RE: Cloverleaf TIS Response to Comments

Kellar Engineering (KE) comment responses in **blue** font.

## School Pedestrian Routing to Lewis Palmer High School (0.2 miles)

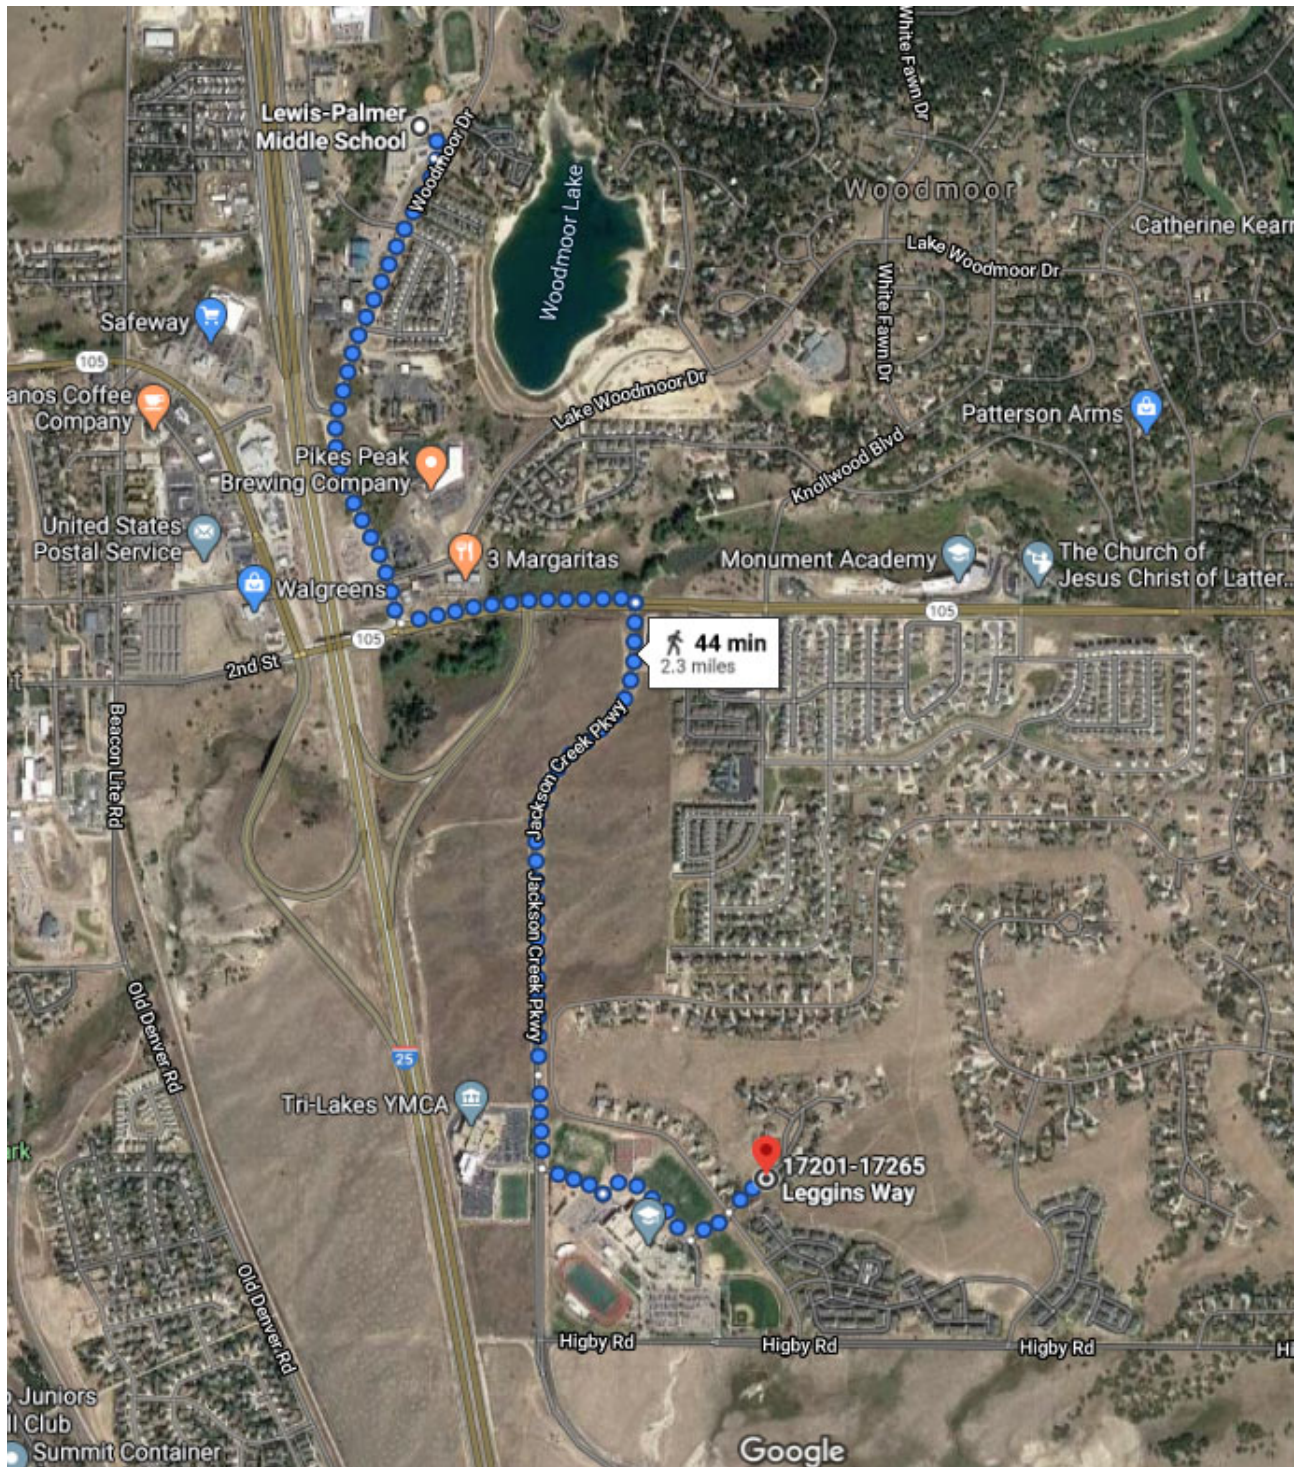
7. Comment. There is no pedestrian path on Leggins Way or crossing at the intersection of Leggins Way/Bowstring Rd. and Leggins Way does not appear to have adequate should to be used by pedestrians. Staff does not see how the existing improvements support the conclusion that adequate pedestrian routing to Lewis Palmer HS exist between this development and the school. Include proposed recommendation for improvements that need to be done to provide adequate pedestrian routing.

Response. A 6' breeze trail adjacent to the south edge of Leggins Way, from White Clover Drive to Bowstring Road is now proposed. Additionally, crosswalk striping and two W11-2 pedestrian crossing signs are also now proposed on Bowstring.

Appendix E: Sight Distance

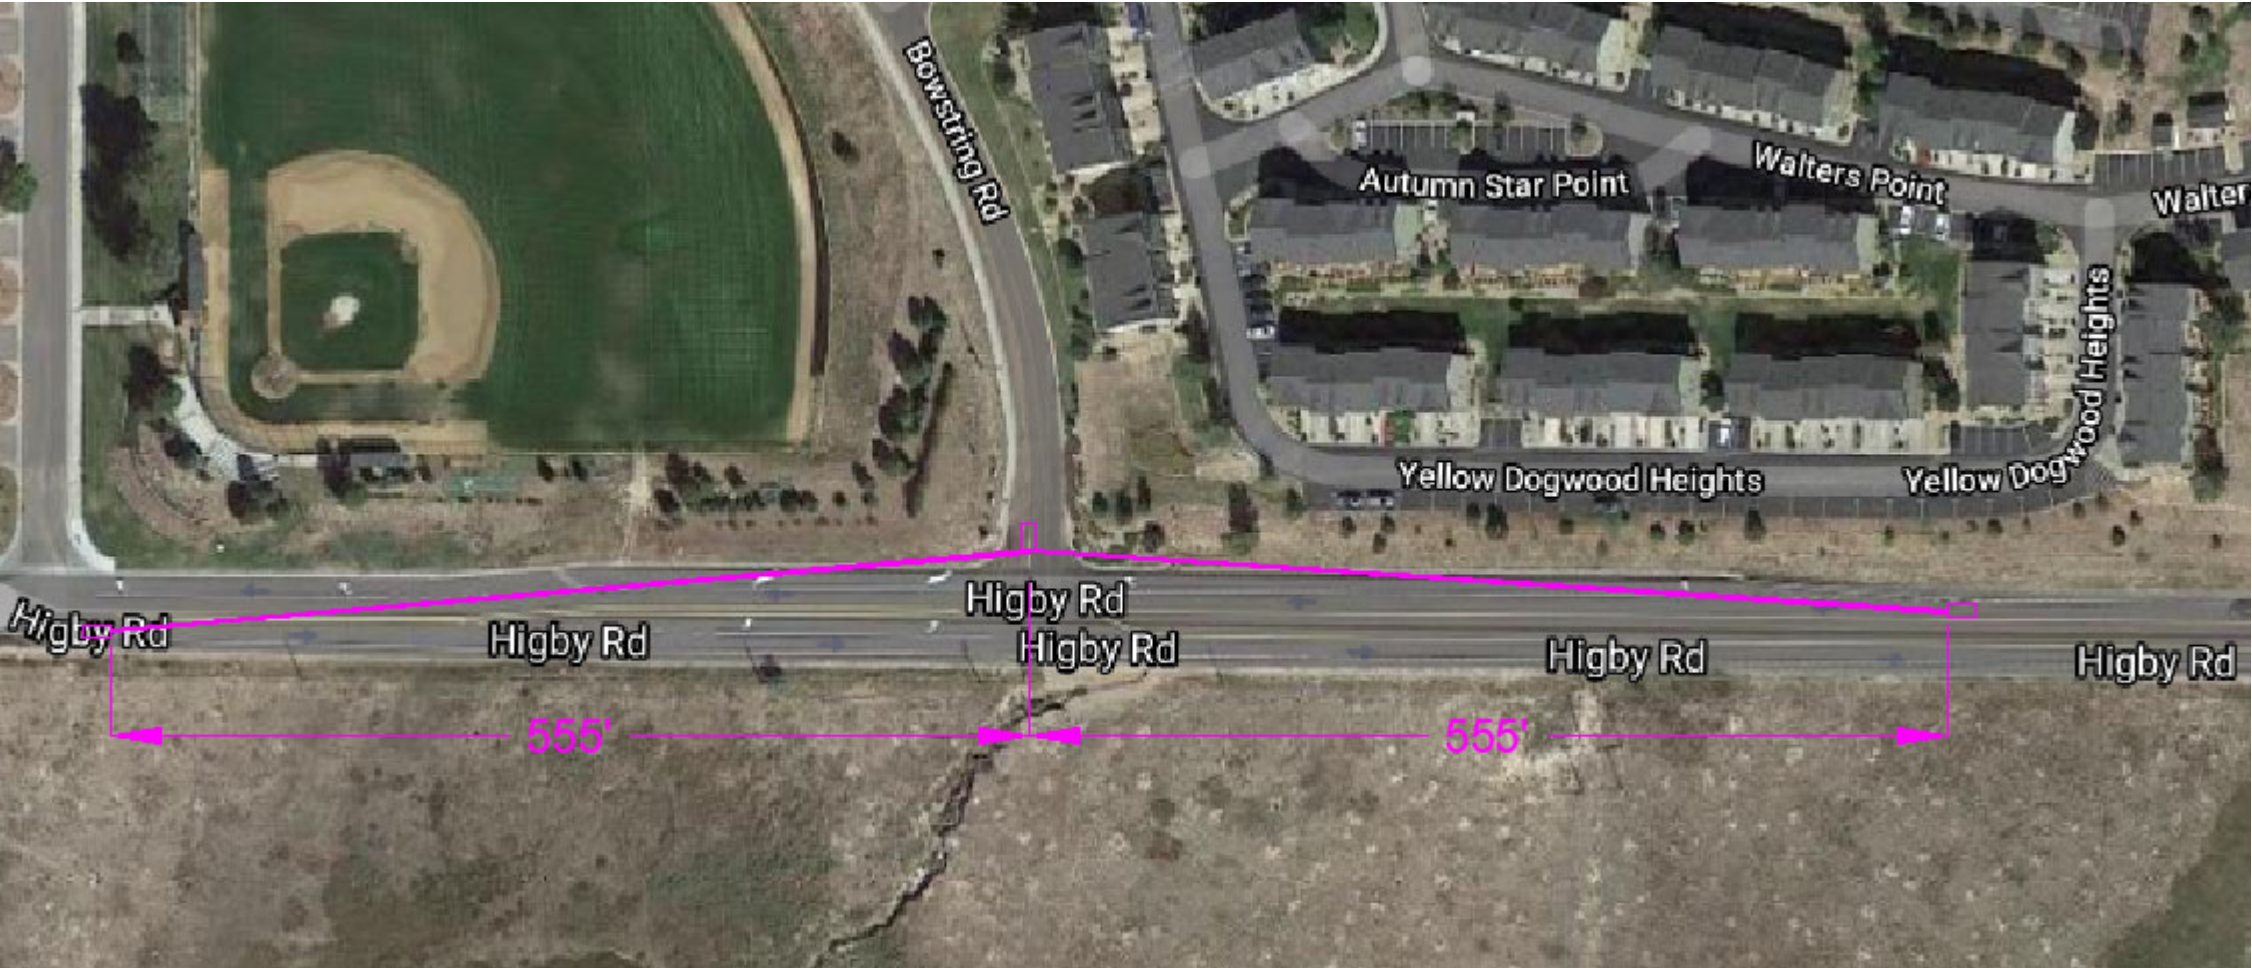
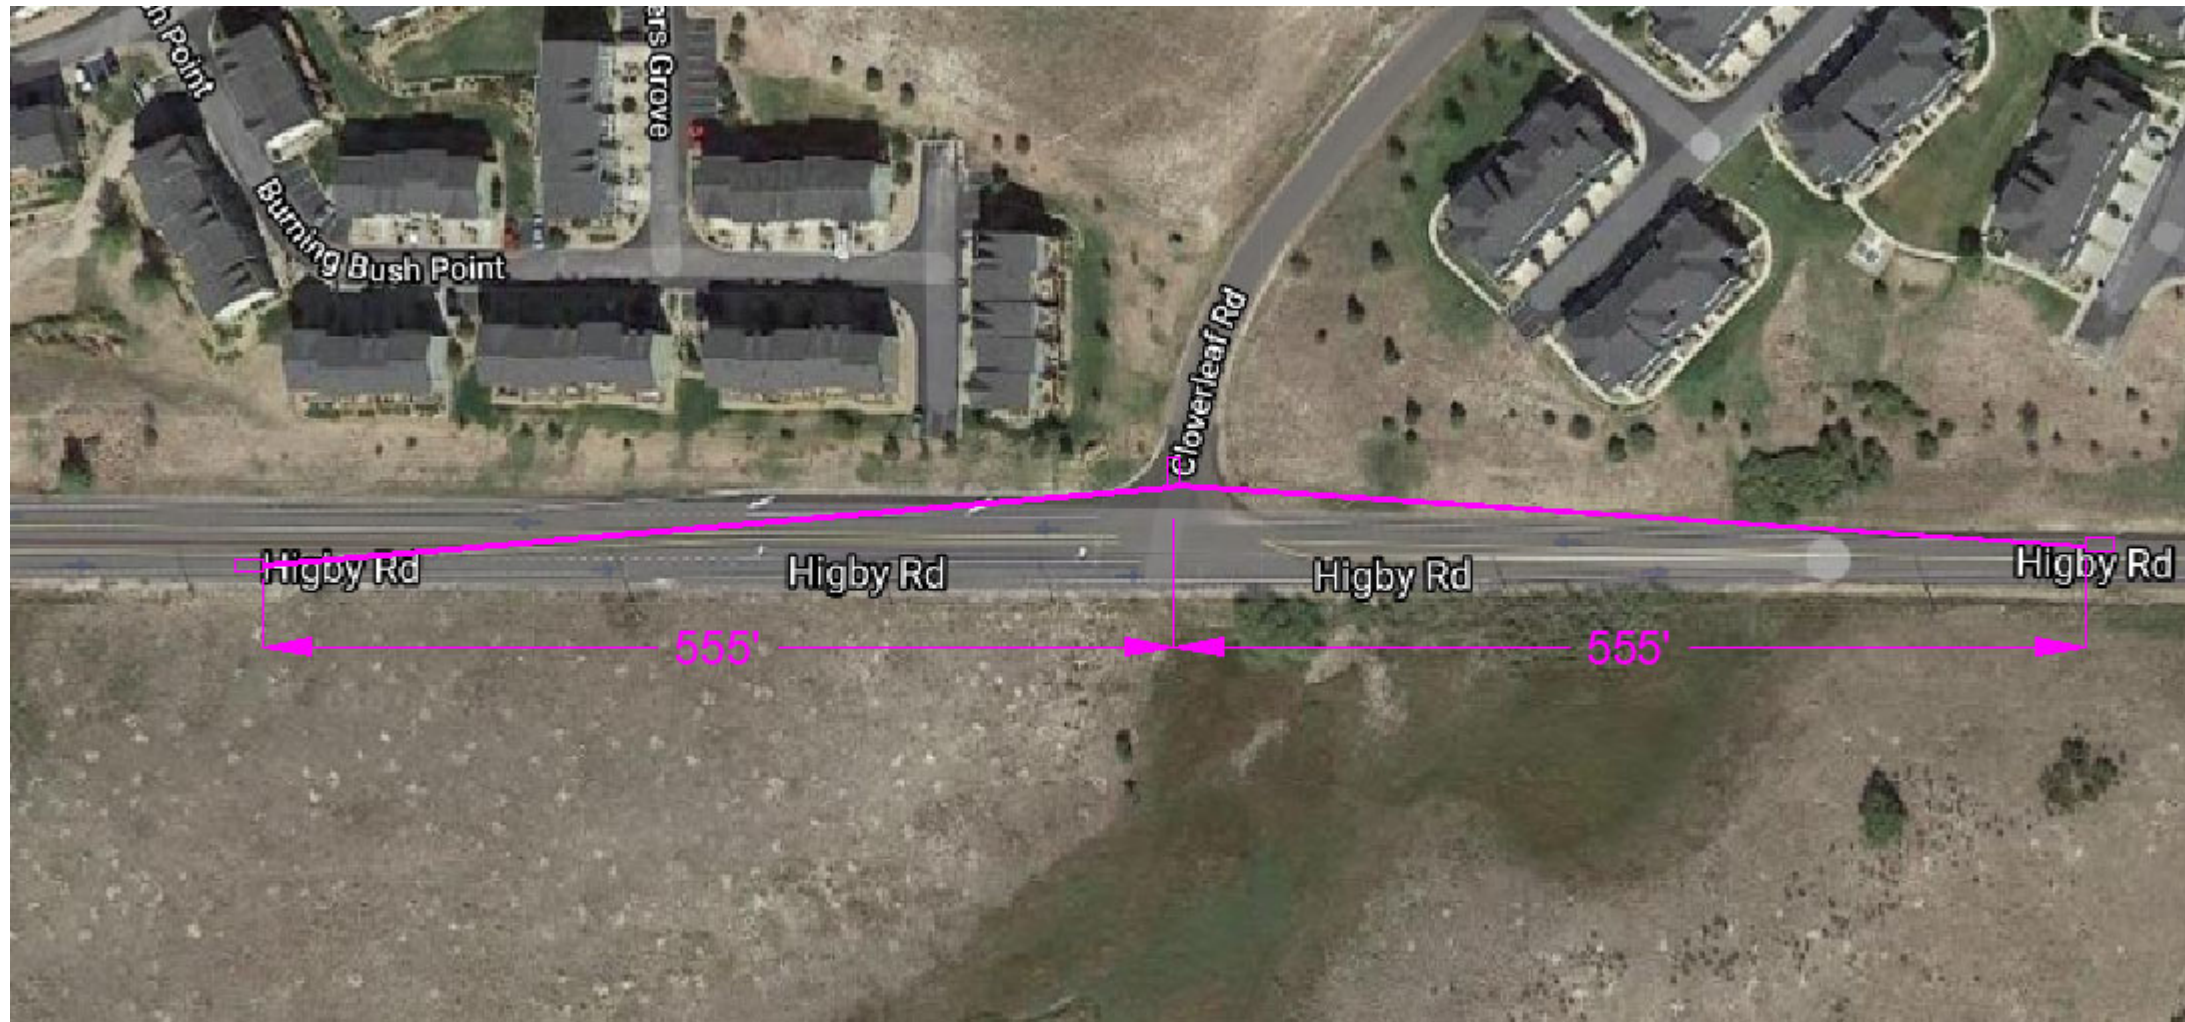
6. Comment. Add a section for sight distance analysis/recommendation at the proposed access locations. Include an exhibit showing the sight distance.

Response. See updated civil drawings and submitted sight distance Deviation Request Form. TIS Section 4.7 has also been updated accordingly.
